From: Contact Centre (CRM) <contact@ribblevalley.gov.uk>
Sent: 09 January 2024 13:00
To: Planning
Subject: Planning Application Comments - 3/2023/0929 FS-Case-575841023

Planning Application Reference No.: 3/2023/0929

Address of Development: 1 Talbot Street, Chipping, PR3 2QE

Proposed Site Plan
1 : 200

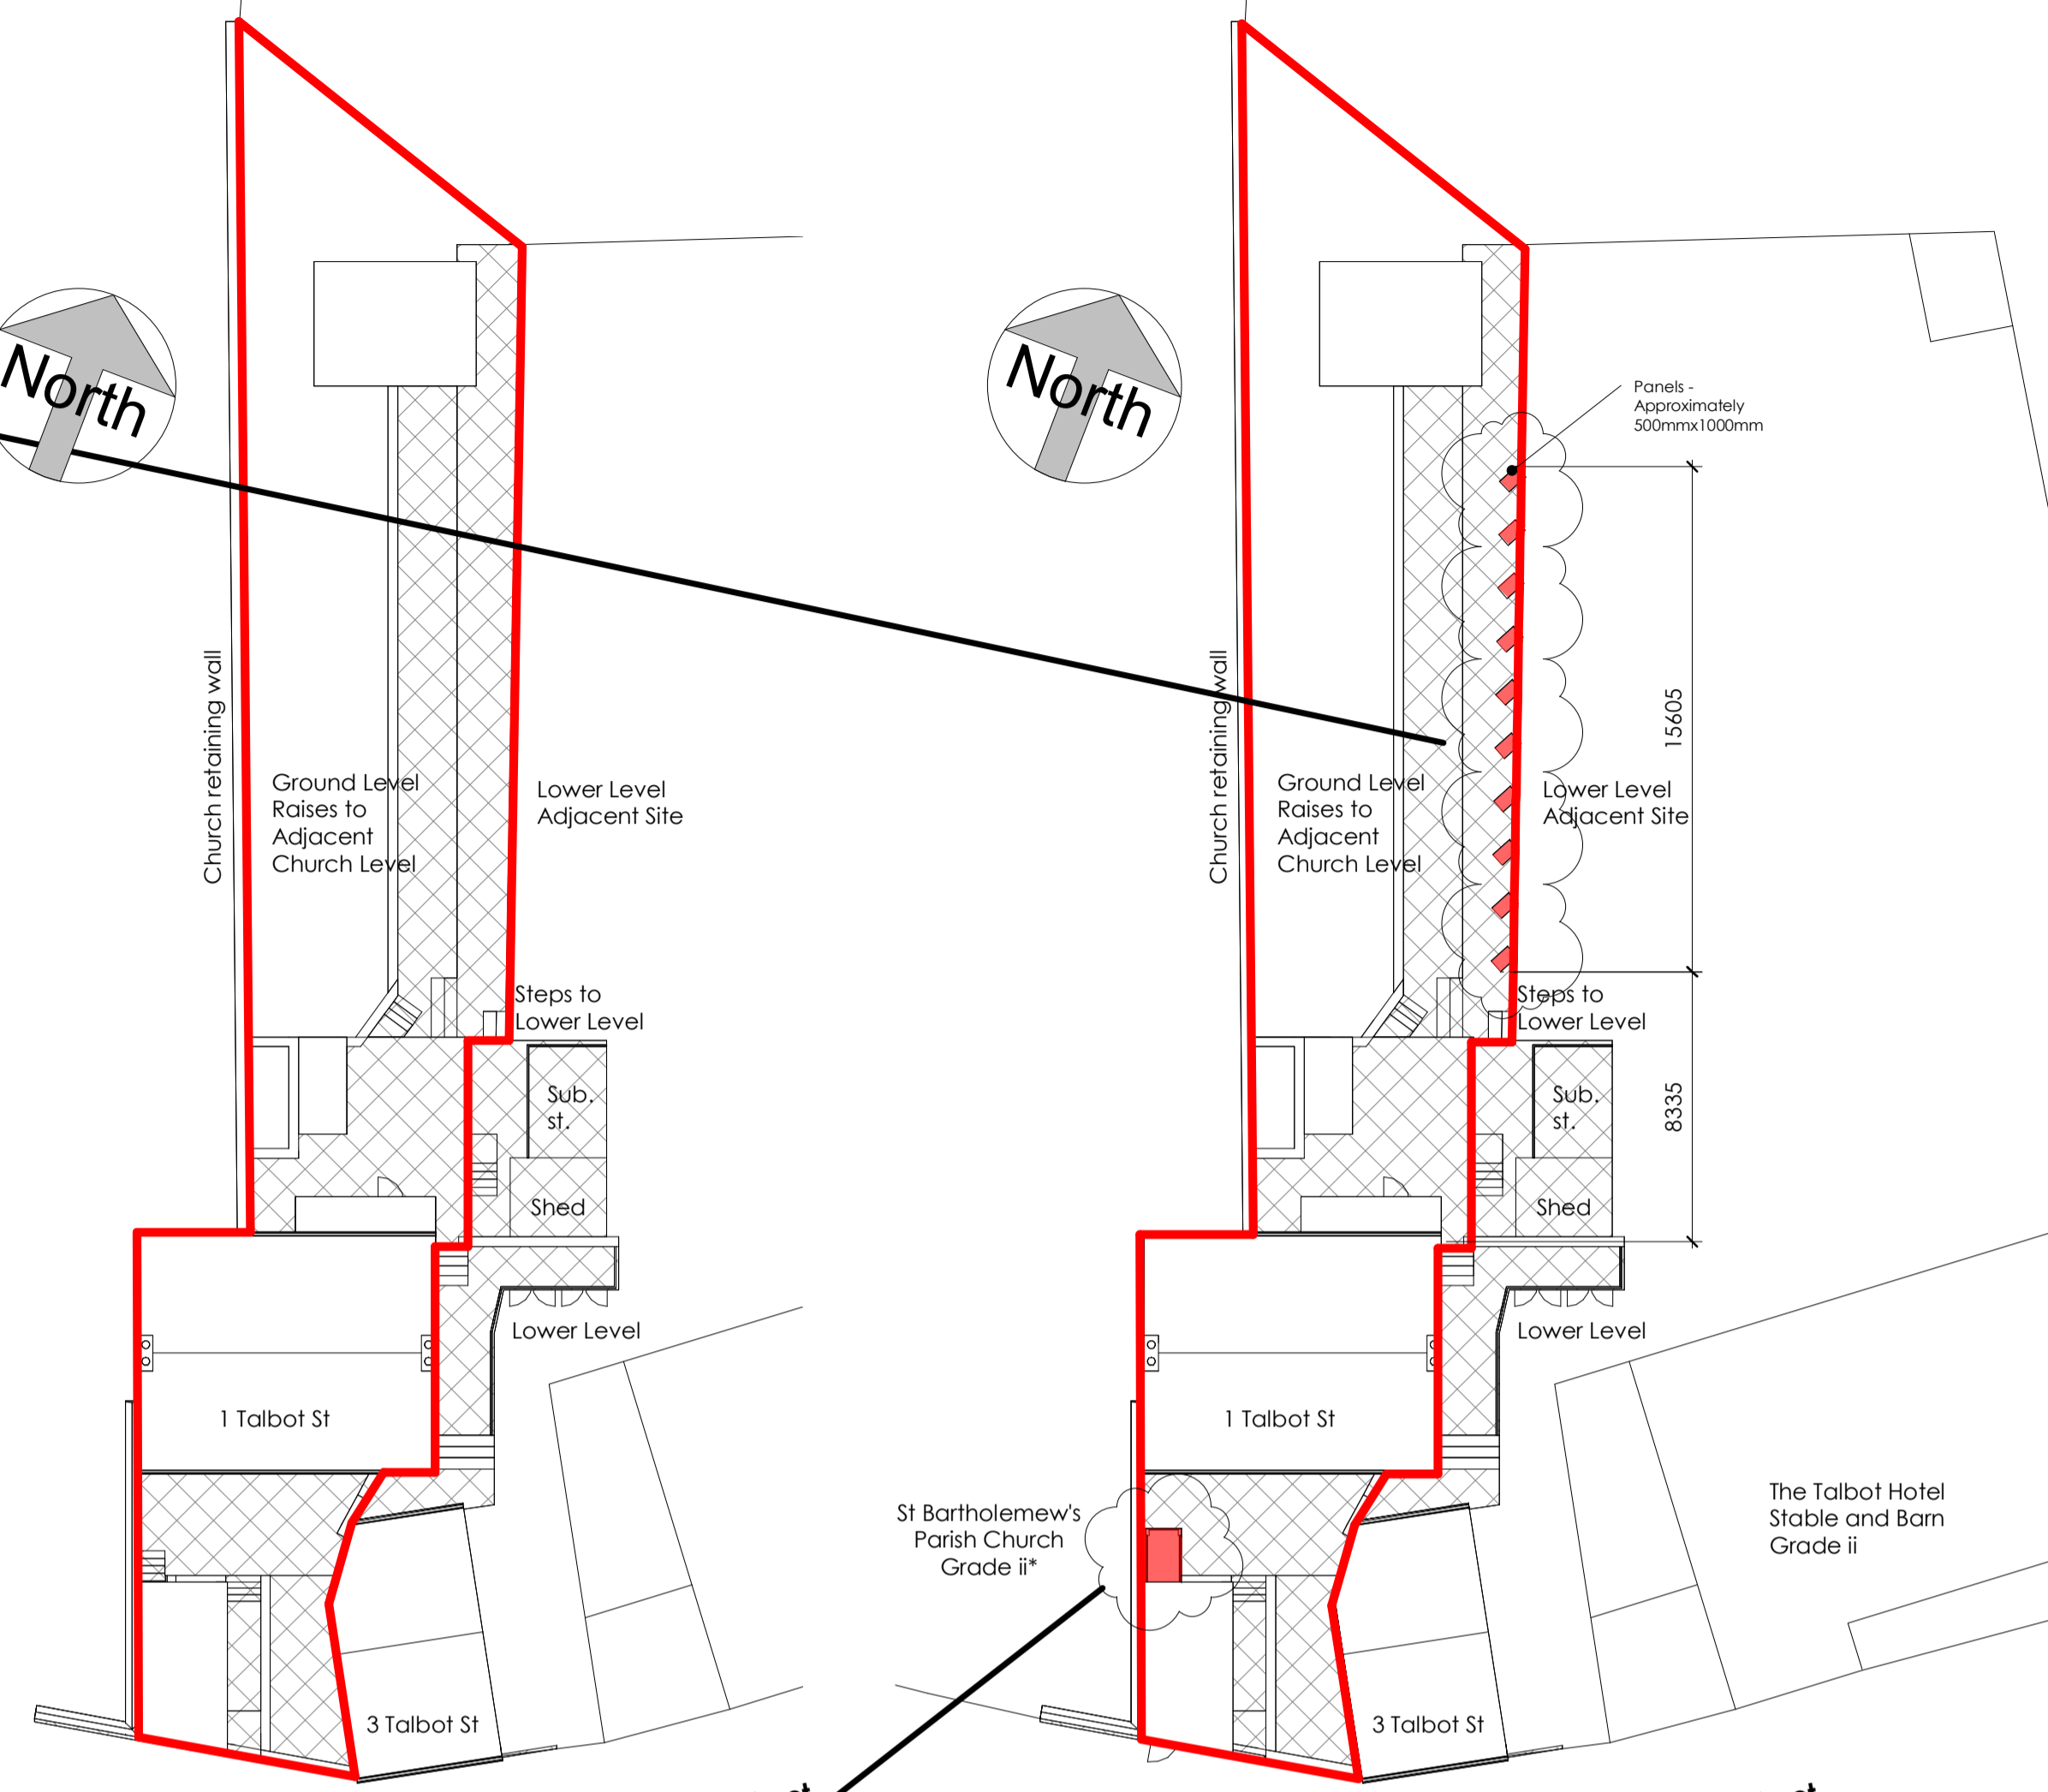
Comments: The boundary line at the rear of the property where the individual is proposing a fence and solar panels is incorrect within the drawings. The individual is claiming to own land that doesn't belong to him.

Please see title deed at the land registry LA871217 (The Barn at The Talbot Hotel). Firstly you will note that from the title deeds, where his shed is currently located, this actually belongs to No 3 Talbot street. This is identifiable by the boundary line on LA871217 at the edge of the electric sub station, there is a grey line that goes to the corner of the rear of No 1 Talbot Road and then from there to the raised wall on the left of the sub station belongs to No 3 and not No 1. Also it should be noted that the sub station is again on the land owned by the Barn at the Talbot Hotel, Currently under the number 5 Talbot street (Until address reallocation). This does not belong to the applicant.
